KITTITAS COUNTY

MEMORANDUM

FROM: Kelly Bacon, Engineer Technician I *KB*

SUBJECT: Riste Short Plat SP-15-0007

DRAWING TYPE: SHORT PLAT APPLICATION

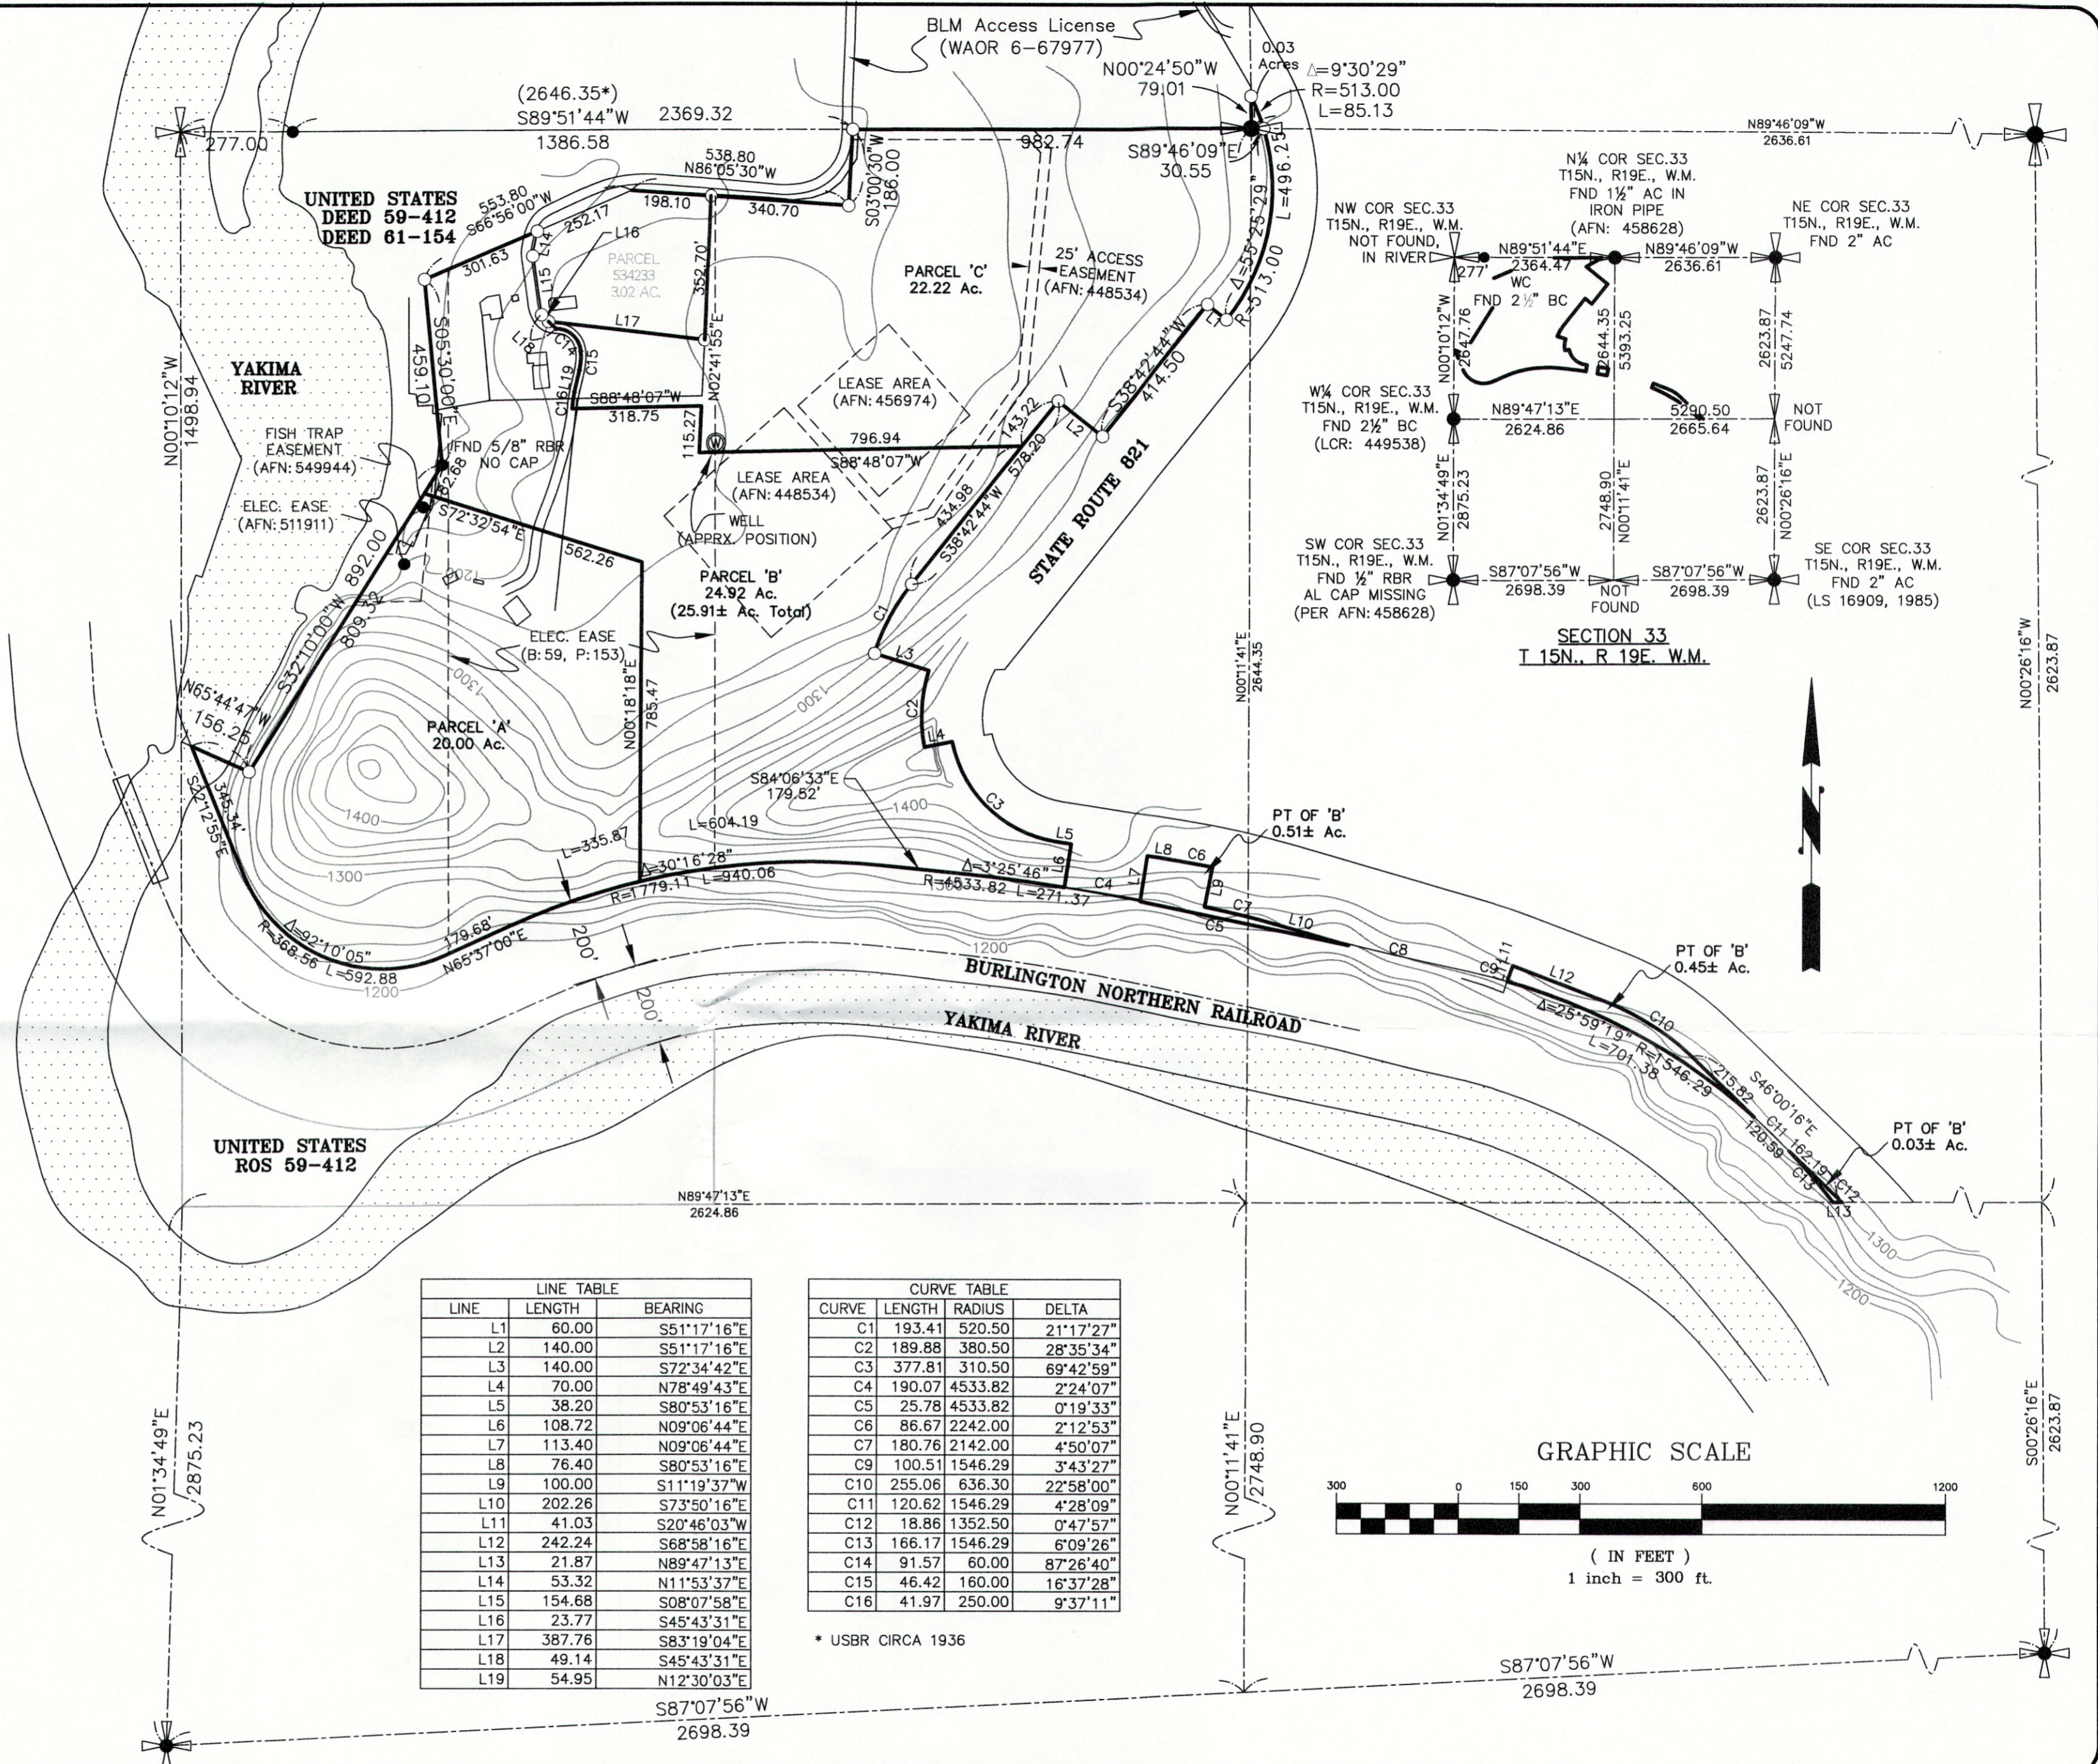
1. An access easement for Parcel "A" of the Riste Short Plat needs to be shown on the face of the short plat.
2. No driveway or road shall be constructed within five feet of the side yard boundary, unless the driveway or road is part of an easement shared with the neighboring property owner.

3. Driveways: A driveway shall serve no more than two tax parcels. See Kittitas County Road Standards, 12/15/15 edition.
 - a. New access easements shall be a minimum of 30' wide. The roadway width shall have a minimum width of 12' if the length of the driveway is less than 150', or 16' if the length of the driveway is more than 150'.

- b. Maximum grade shall be 15%.
 - c. Crushed surface depth per WSDOT standards.
 - d. Maintenance of driveway approaches shall be the responsibility of the owner whose property they serve. The County will not maintain accesses.
